09/17/2018

Proposed change for 38 Noyes St.

Proposed new wall and door

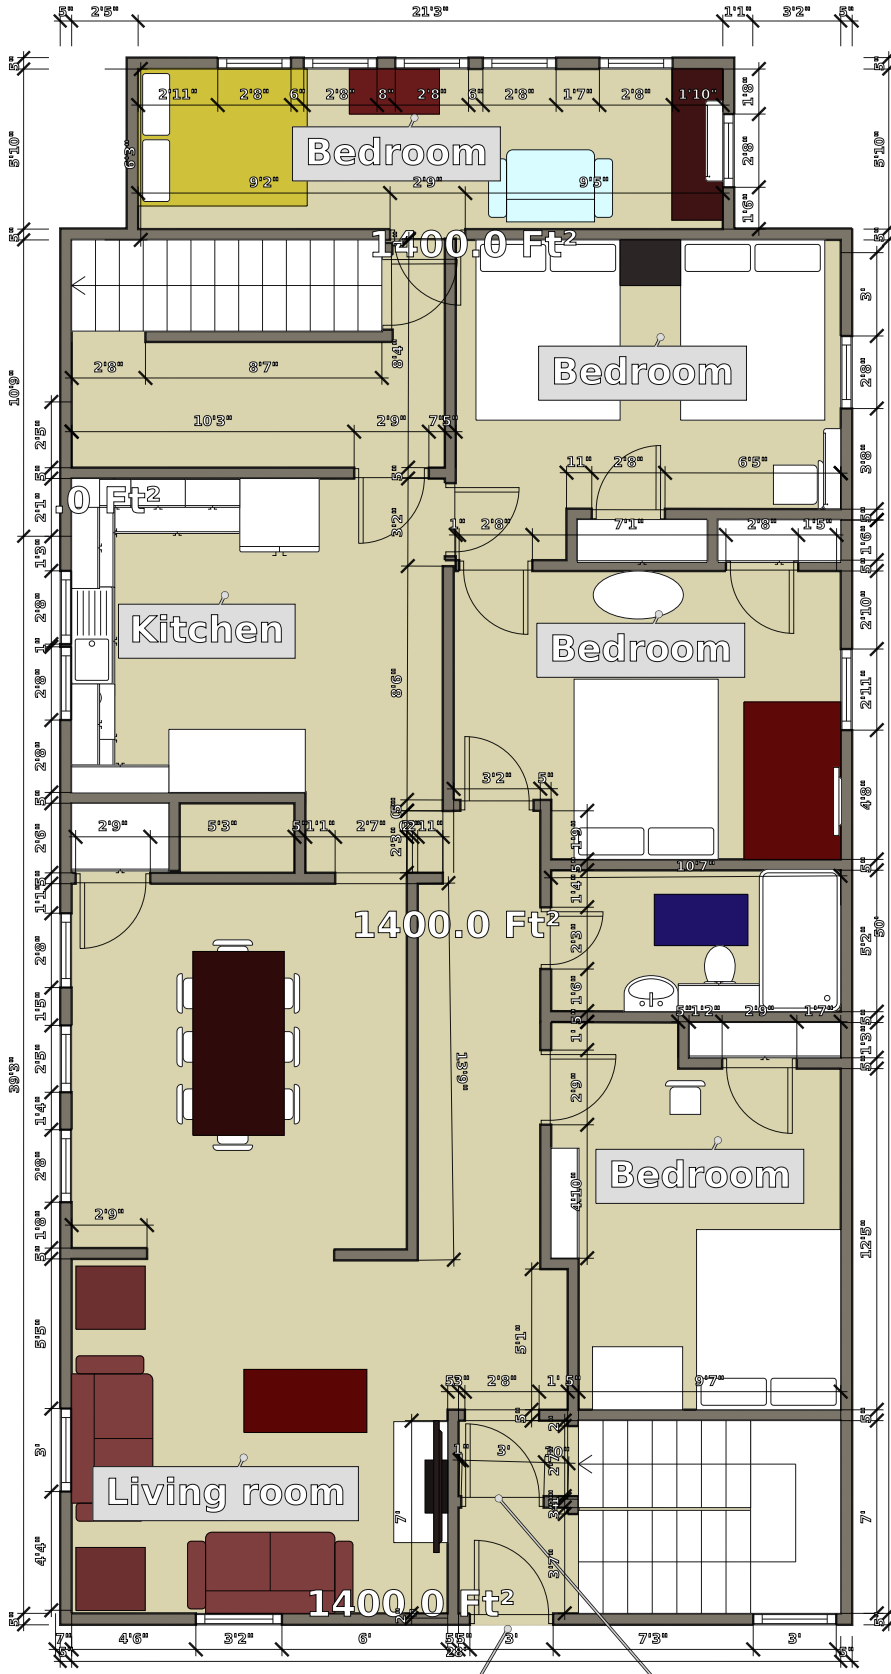
Inspector Kevin Hanscom raised concerns that the finished part of the basement and the first floor could be considered separate units, even though they are not used as such and have never been rented as such. In order to eliminate any doubt I would like to remove the existing doors from their frames for entrances to the first floor and basement, leaving an empty door frame, then construct a 4'4" wall, 5" thick, using 2x4" construction with 1/2 drywall on either side, and containing a 36" x 80" left hand swing steel door with steel frame, 90 minute fire rated, Masonite model 740859, in front of both the existing first floor and basement doors. This will result in a single 3' door serving as the entrance for both spaces, and no way to lock one space from the other.
